Town & Country Planning Act 1990 (as amended)
Town and Country Planning (Development Management Procedure) (England) Order 2015
Application for approval of details reserved by condition imposed under planning permission
LU/56/17/PL relating to Condition No. 3 (Noise report), 6 (Refuse management statement) & 8
(Grease trap specification)
22 Beach Road & 3 Evans Gardens Littlehampton,,

Arun District Council have decided to **REFUSE details reserved by condition for the following reasons:**

PROPOSED REAR ELEVATION

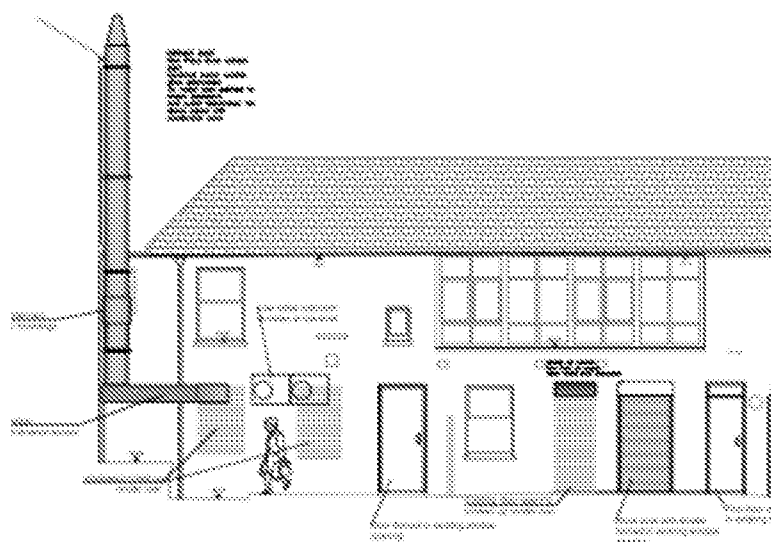
As detailed within 'Acoustic Assessment - 131718 Rev A' the proposed ventilation system and cooling fans to the chillers at Pizza Hut, 22 Beach Road, Littlehampton will result in 'break out' noise which is too loud and fails to identify suitable mitigations methods which will satisfactorily deal with this in such a way as to prevent detrimental harm to the amenity of nearby sensitive receptors.

The assessment has also been prepared on the basis that the most affected rooms will be situated at first floor level. However, the extent of the significant adverse effect of these new sources of noise mean that it is also likely to have an unacceptable adverse effect at second floor level where distance attenuation is likely to have little effect.

Furthermore, whilst relocation of the chiller fans to the bike/moped storage cupboard/ garage may reduce their effect on residential accommodation to the main body of the premises, no explanation has been provided as to how the chiller fan noise will now impact proposed residential accommodation in the on back extension above this storage space. There is also no consideration of the need for (acoustically treated) ventilation which will be necessary to this 'garage.' The applicant should also provide clarification as to whether there will be sufficient space for the existing number of mopeds to continue to be stored here once the chiller units are placed here.

Other than for the background readings, the report seems to be based purely on calculation from the manufacturer's specifications. It is suggested that a more robust report would be based upon actual noise measurement of the equipment which is now in place and operational. Fan noise should be demonstrated at high and low speed.
